City of Albuquerque Stormwater Construction Site Inspection Report

ESC File No.	H18E070	Project Name:	McDonald's 30-0001
NPDES Id. No.	NMRT005YE	Location:	5900 Menaul Blvd NE
12/14/2023	Owner	Contractor	
Operator	McDonald's USA, LLC	Barnsley Construction	
Contact name & title	Alex Breeden	Ray Casias	
e-mail	alex.breeden@us.mcd.com	rayc@barnsleyconstruction.com	
Contact Phone #	630-207-0289	505-856-5576	
COA Inspector	Chancellor English	Start/End Time:	1:30pm
Construction Phase:			
Type of Inspection:	Regular	Storm Event	Post Storm Event >0.25"
Weather at time of inspection?		Cloudy	Temperature: ~ 45
Estimated date of last storm 0.25" or greater		12/14/2023

EROSION CONTROL PLAN
C3.0

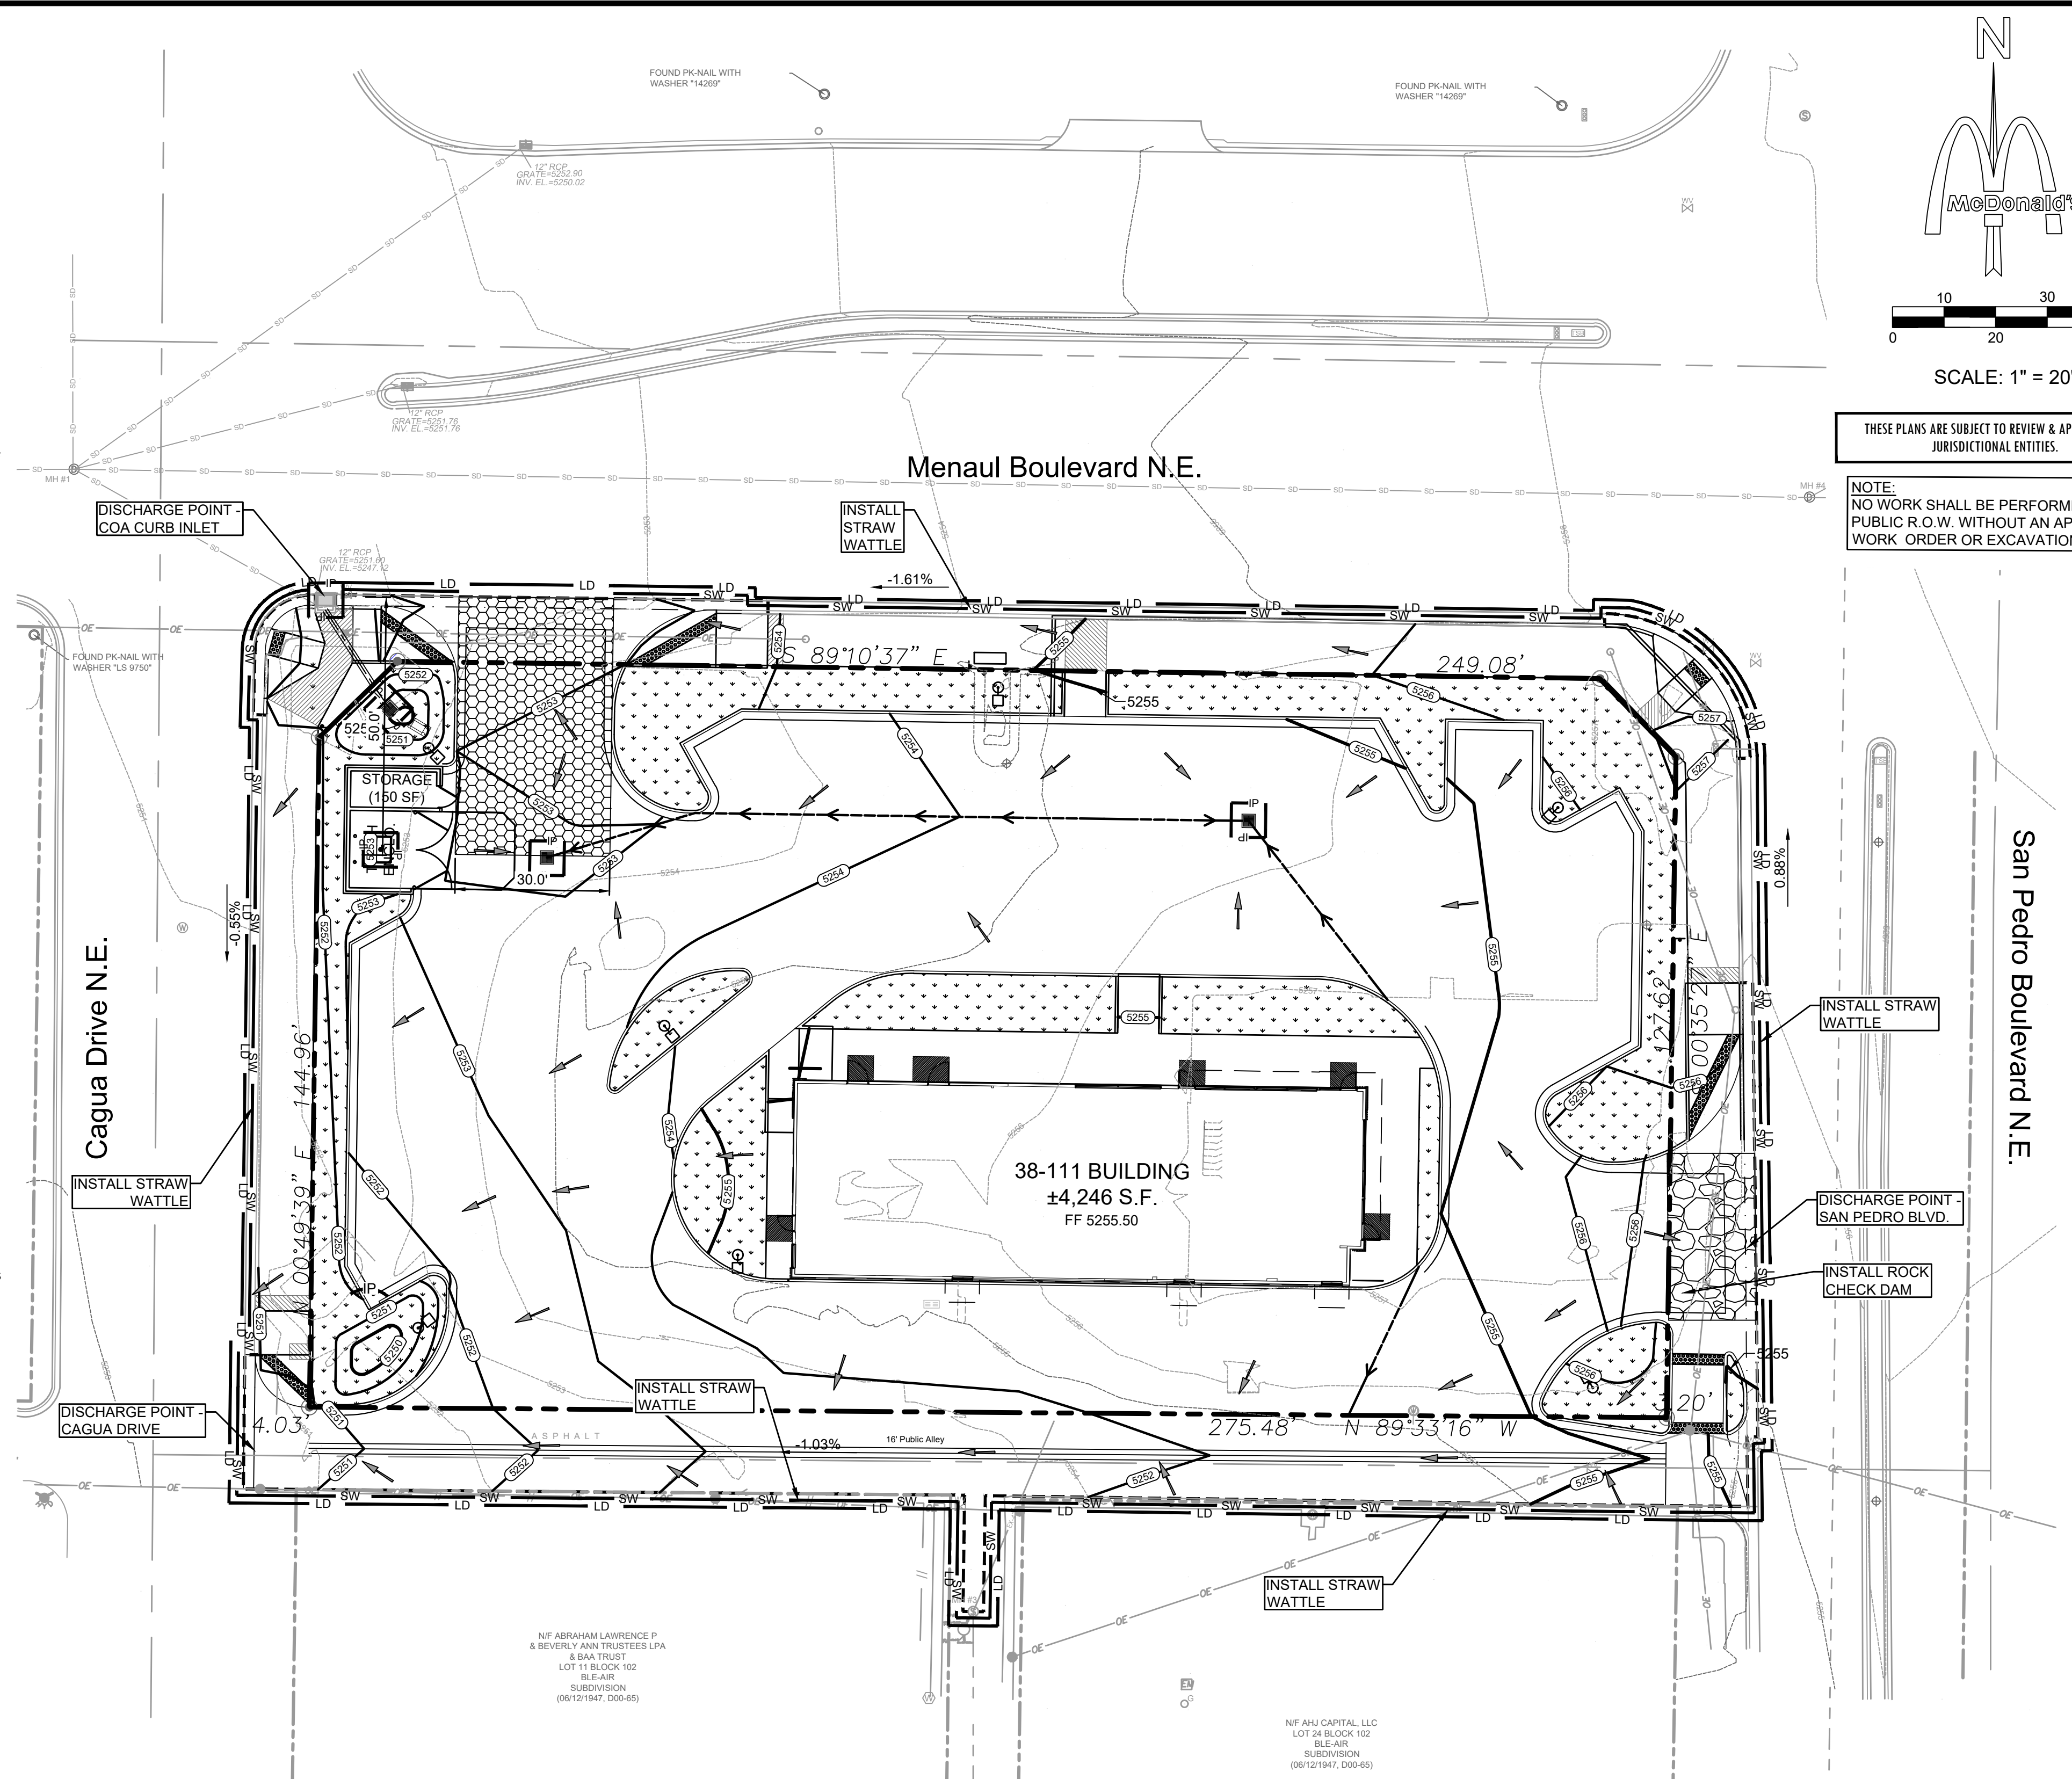
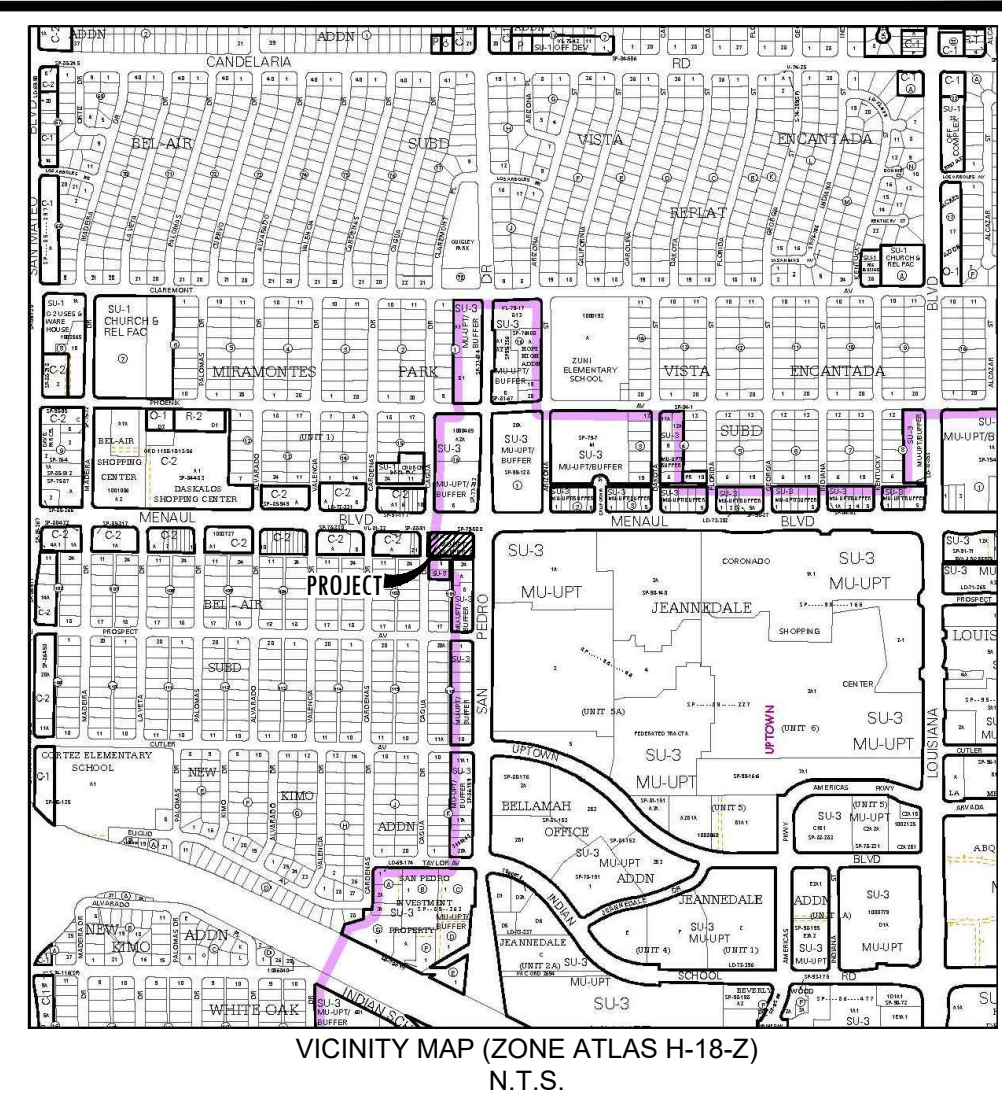
Item Number	Deficiency/ Corrective Action
1	The self-inspection reports are missing both of the operators' signatures in violation of CGP Part 4.7.2. The modified SWPPP map showing the new construction exit location is missing certification of the operators in violation of CGP Part 7.4.3 Required mitigation: Each inspection report and SWPPP modification must be signed by the operator's signatory in accordance with CGP Appendix G, Part G.11. You must also maintain records showing the dates of all SWPPP modifications which must include the name of the person who authorized each change per CGP Part 7.4.2. Please note that the Delegation of Authority to sign inspection reports and SWPPP modifications cannot be to a third party, and must be a representative of each operator.
2	Track-out - Sediment has been tracked-out of the site in violation of CGP Part 2.2.4. Required mitigation: Implement additional track-out controls as necessary to ensure that sediment removal occurs prior to vehicle exit, and where sediment has been tracked-out from your site onto paved roads, sidewalks, or other paved areas outside of your site, removed the deposited sediment by the end of the same business day in which the track-out occurs, as per CGP Part 2.2.4.
